WEST SUSSEX COUNTY COUNCIL CONSULTATION

TO:	Arun District Council FAO: Silvie Steiningerova
FROM:	Highways, WSCC
DATE:	15/09/2026
LOCATION:	1 Sark Gardens, Ferring, BN12 5QB
SUBJECT:	FG/85/26/HH Single storey side extension, changes to external rendering, and alterations to fenestration. Relocation of garden wall and installation of 1.8m fence. New permeable resin driveway with dropped kerb.
DATE OF SITE VISIT:	N/A
RECOMMENDATION:	Advice

BLOCK PLAN

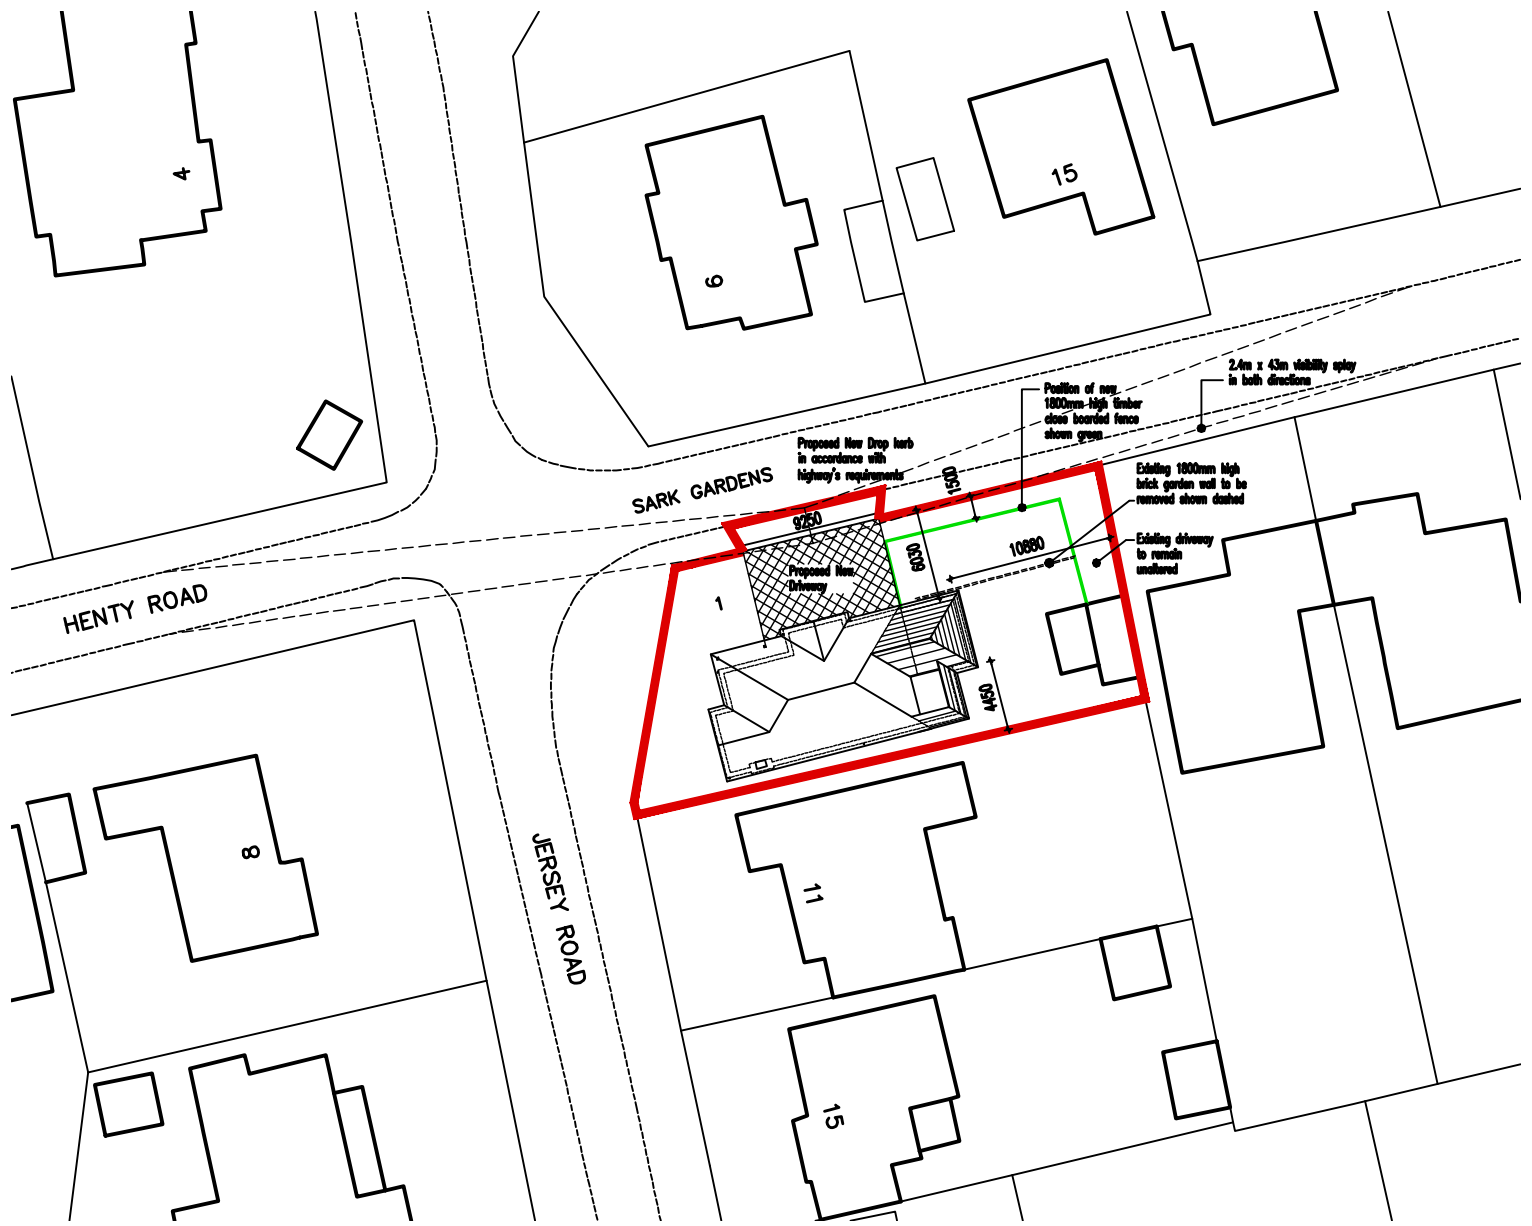
A new 9.25m wide dropped kerb is proposed on Sark Gardens to facilitate access to a new driveway. From inspection of the submitted site plan, suitable visibility splays of 2.4m x 43m have been demonstrated in both directions. As Sark Gardens is privately maintained, the applicant will need to obtain formal approval from the road's proprietor to undertake the proposed access works.

On-site turning does not appear achievable within the proposed driveway, so cars may have to exit the site in a reverse gear. However, this is not anticipated to give rise to a highway safety concern, owing to suitable demonstrated visibility either side of the proposed access.
